Date: 12 January 2023
Our ref: 417158
Your ref: EN010106

NSIP Reference Name / Code: Sunnica Energy Farm, EN010106
Natural England's comments in respect of Sunnica Energy Farm Project, promoted by Sunnica Ltd

Examining authority's submission deadline 5, 13 January 2023

2. Comments on Appendix A to Written Summary of Applicant's Oral Submissions at the ISH3: Technical Note: Clarification requested by Natural England on ALC

Appendix 2 - Detailed ALC map

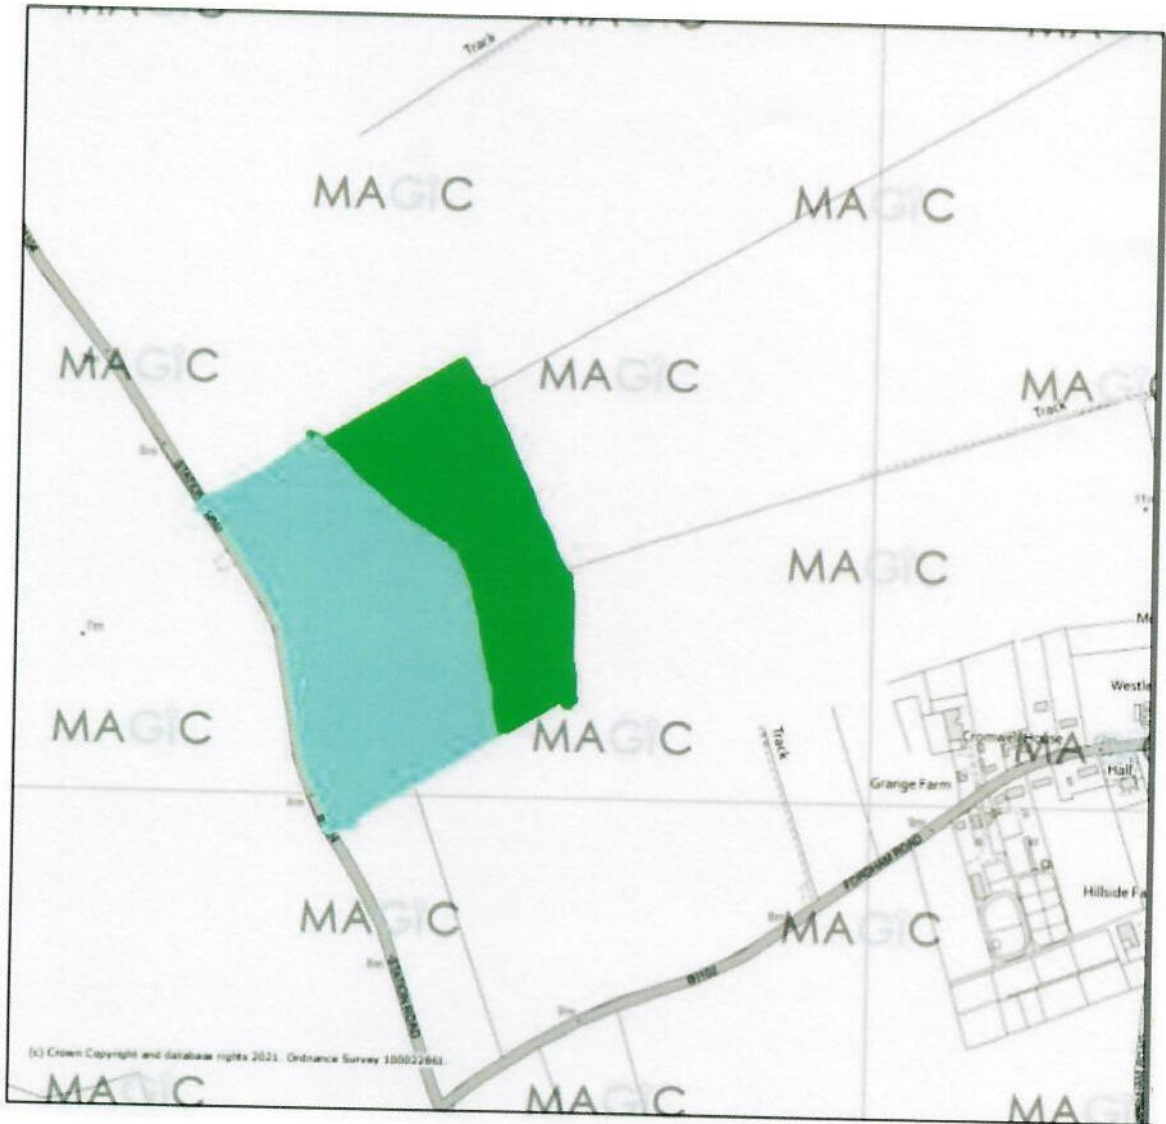
2.3.1. During the call on the 30th November 2022, Natural England queried the lack of mapped Subgrade 3a and Grade 4 in Figure 12-2, not just the absence of Grade 4 as suggested in paragraph 2.1.4.

2.3.2. Furthermore, Natural England queried the lack of mapped Subgrade 3a at Elms Road in Figure 12-2, not the absence of Subgrade 3b as suggested in para 2.1.4.
